Ref: 6/2022/2240/LB  
Date: 20/12/2022

## HISTORIC BUILDINGS AND CONSERVATION ADVICE

**RE: 4 Astwick Manor, Coopers Green Lane, Hatfield, AL10 9BP**

The application is for the insertion of flue to main bathroom to facilitate new boiler.

First Floor Plan
As Proposed - Scale 1:100

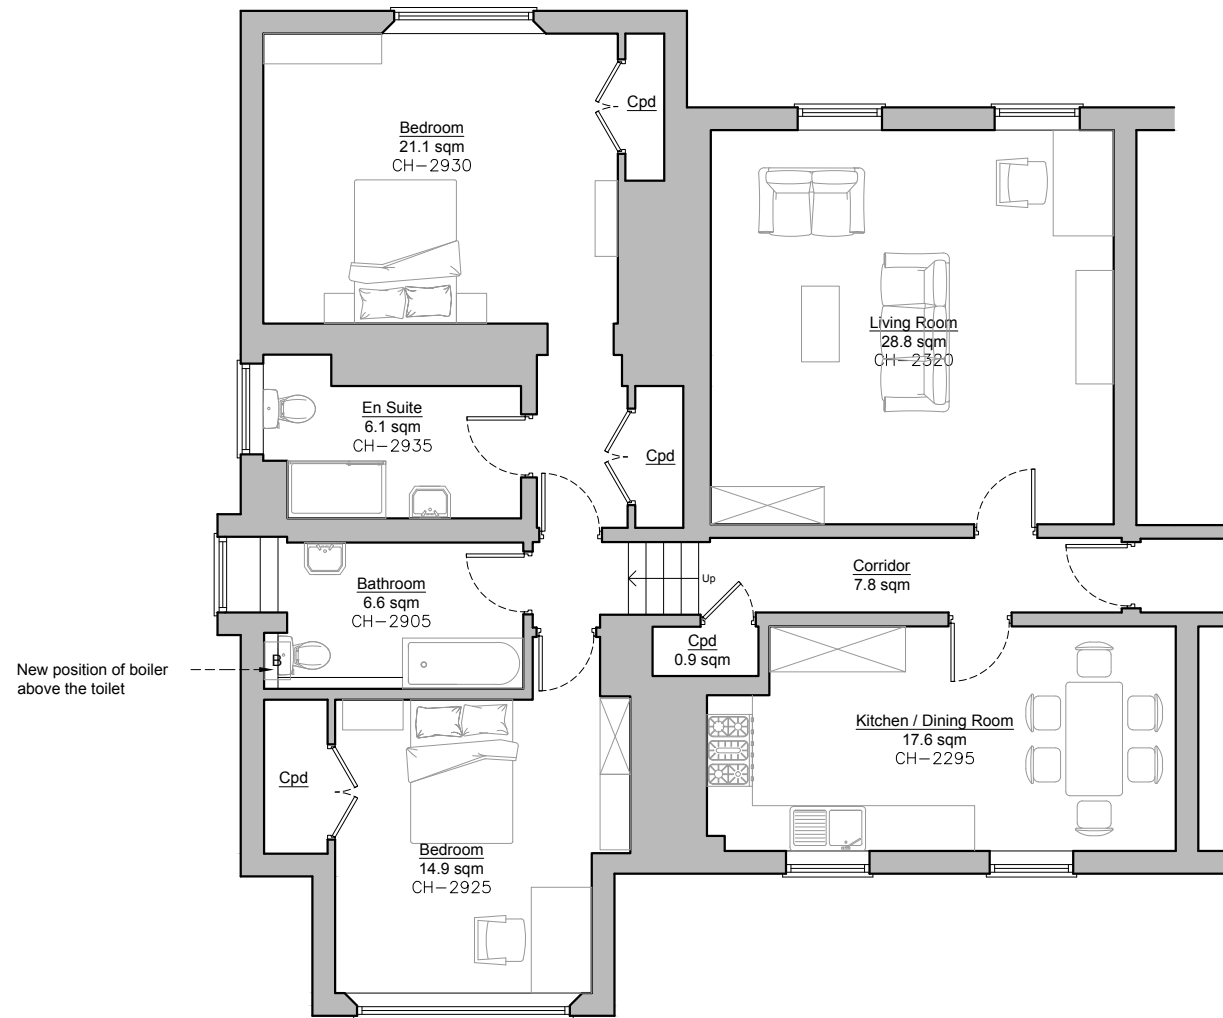
It is proposed to install a new boiler within apartment no.4 with a new flue positioned on the west elevation at first floor alongside a projecting dormer window. The west elevation is well screened from view by the adjoining modern block and the proposed flue will not affect any principal elevations or intrude into key views of the listed building. Whilst there will be some loss of historic fabric, this is considered to be minor and will not affect the building's overall special interest.

There are no objections to the proposal as it will not affect the special interest of the listed building or harm its significance, in accordance with Section 16 of the Planning (Listed Buildings and Conservation Areas) Act 1990 and Chapter 16 of the NPPF. Sufficient detail has been provided with the application so there are no specific recommended conditions.
